**Consultation Response from KC,
Ecology Unit**

2023/93783 Batteyford Playing Fields, Huddersfield Road, Mirfield, WF14 0EE

**Use of land for siting of five storage containers, erection of drying room, recreational space
and associated car parking**

Date Responded: 09/02/2024

PROPOSED SITE PLAN

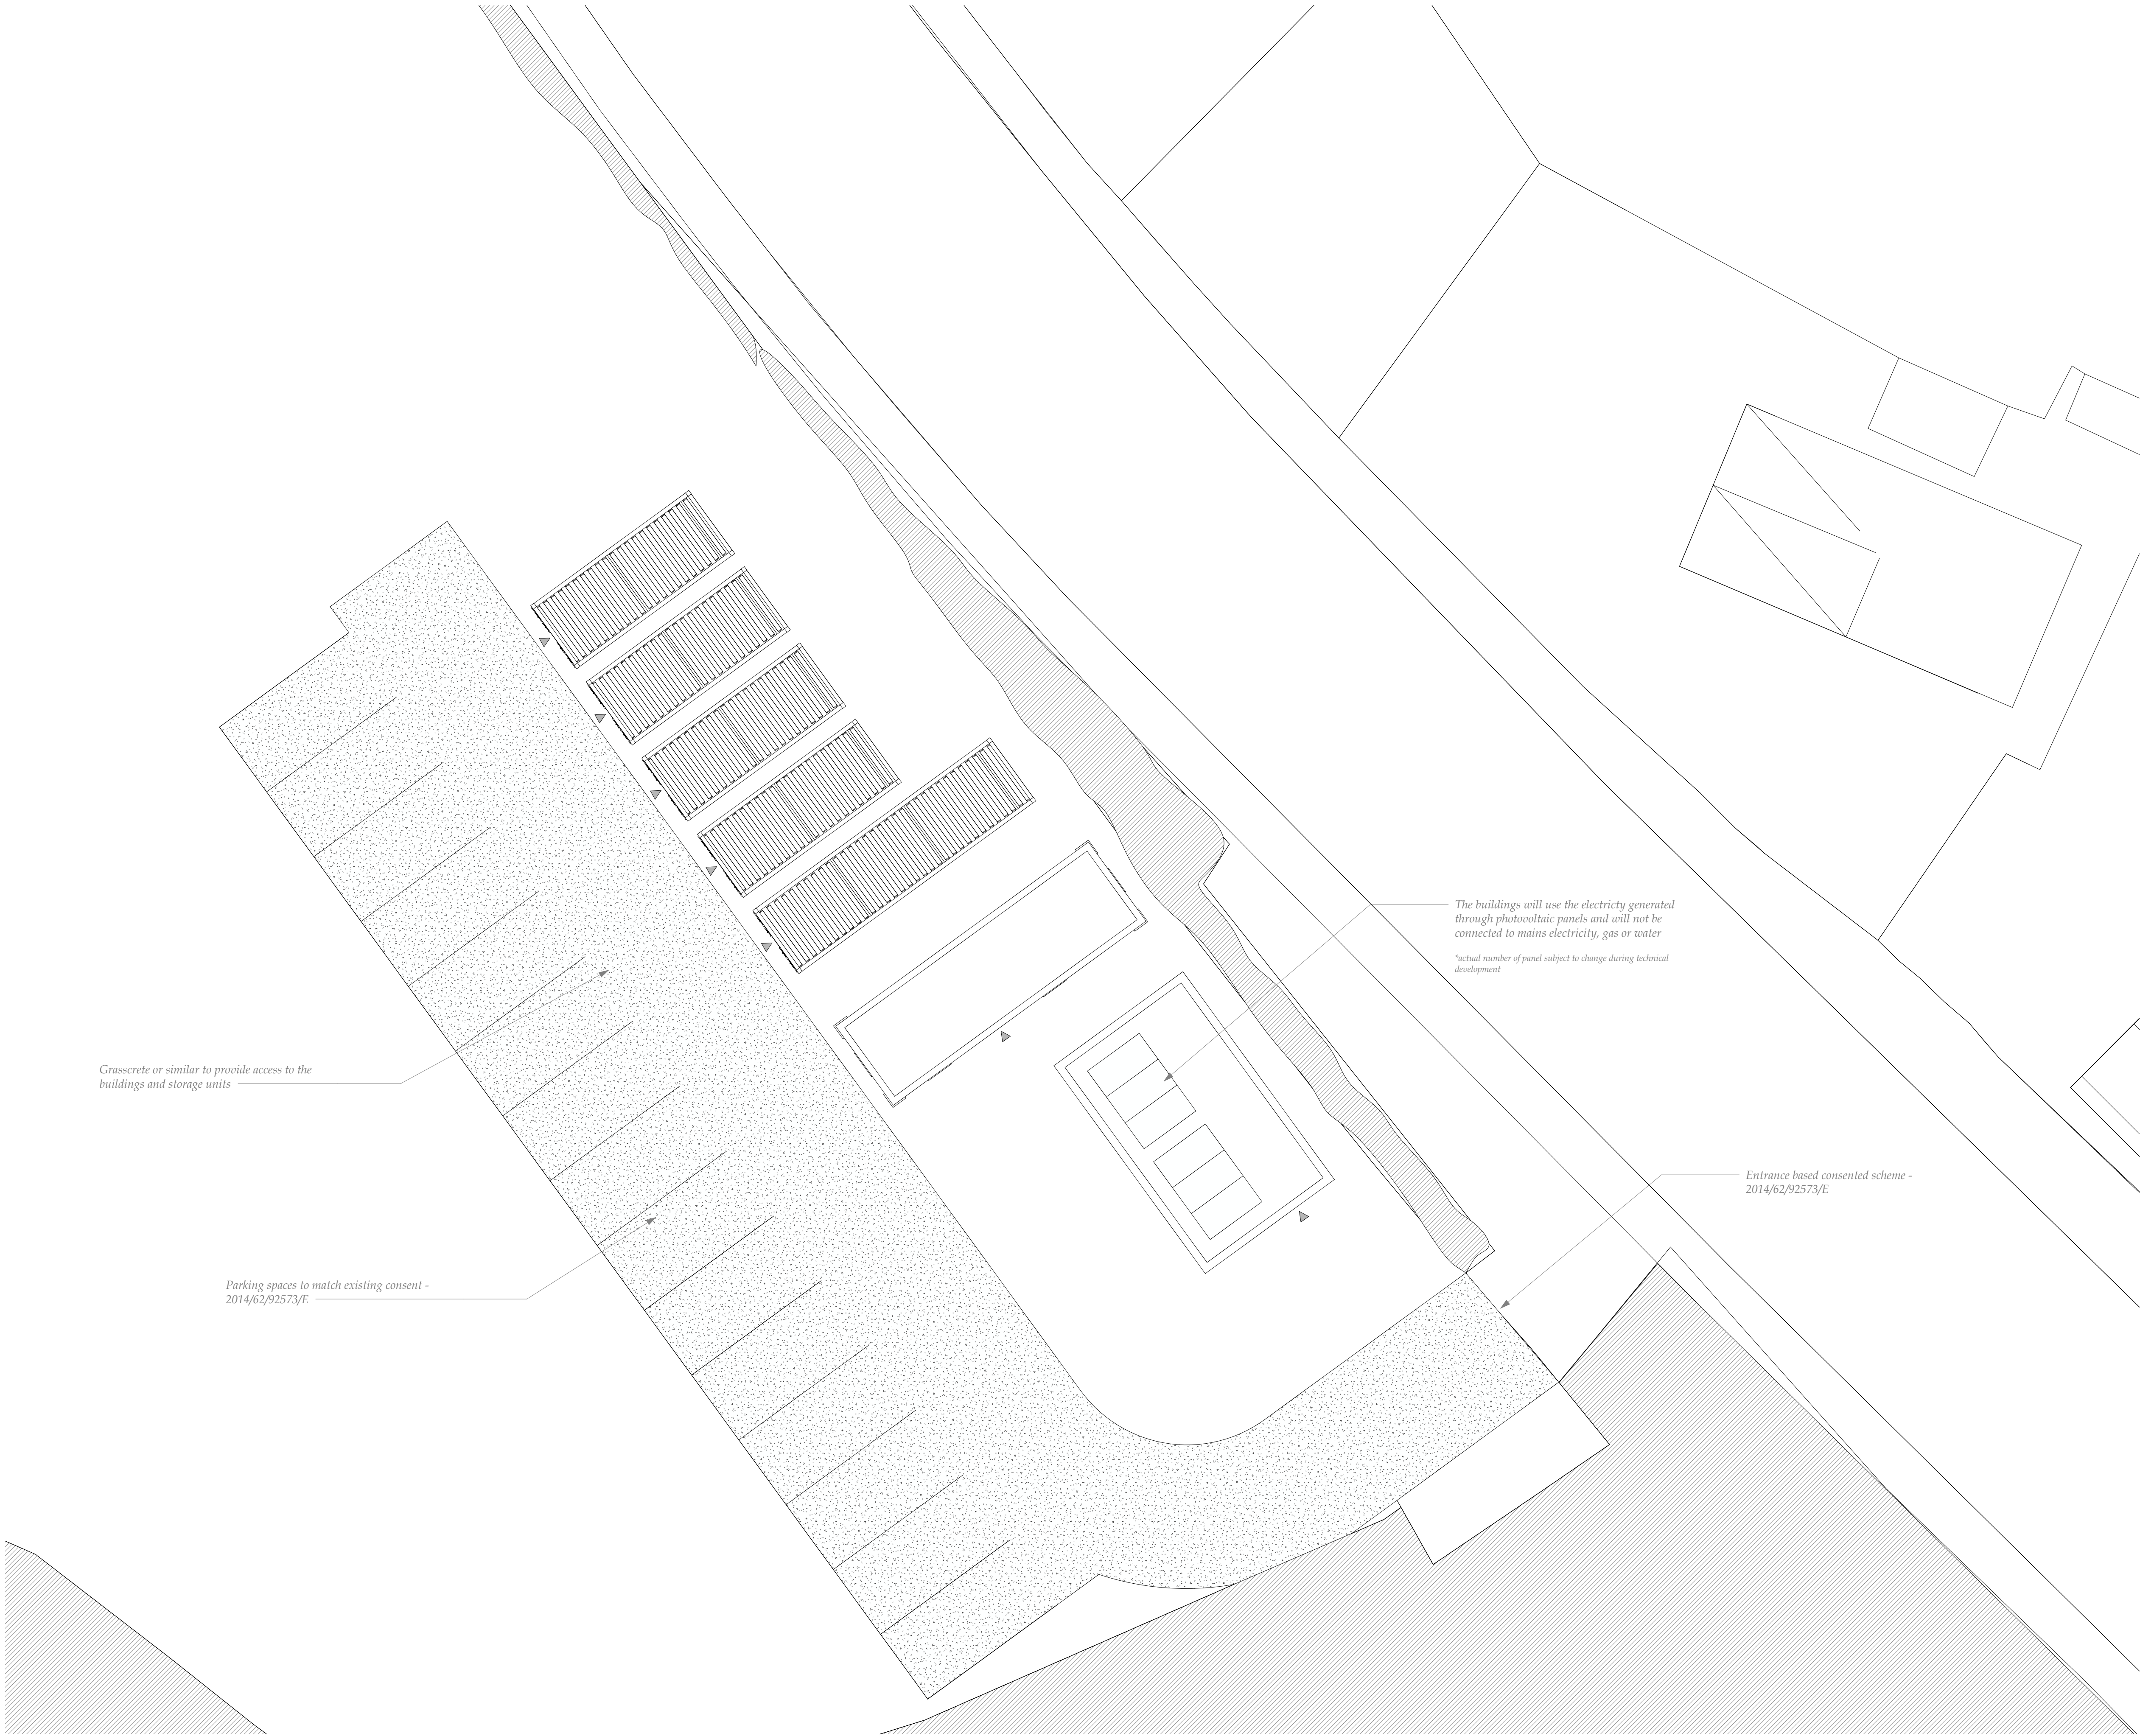
It is anticipated that the proposed development will have minimal impacts on ecological receptors, being already situated within a recreational ground, comprising of modified grassland. However, the operational phase of the development has the potential to cause indirect impacts to adjacent ecological receptors, including the woodland and watercourses, and as such, a lighting scheme should be conditioned, as part of any forthcoming consent, suggested wording of which is detailed below.

1. A “lighting design strategy for biodiversity” shall be submitted to and approved in writing by the Local Planning Authority before operational use of the building. The strategy shall:
 - a. Identify those areas/features on site that are particularly sensitive for bats and that are likely to cause disturbance in or around their breeding sites and resting places or along important routes used to access key areas of their territory, for example, for foraging; and
 - b. show how and where external lighting will be installed (through the provision of appropriate lighting contour plans and technical specifications) so that it can be clearly demonstrated that areas to be lit will not disturb or prevent the above species using their territory or having access to their breeding sites and resting places.

All external lighting shall be installed in accordance with the specifications and locations set out in the strategy, and these shall be maintained thereafter in accordance with the strategy.
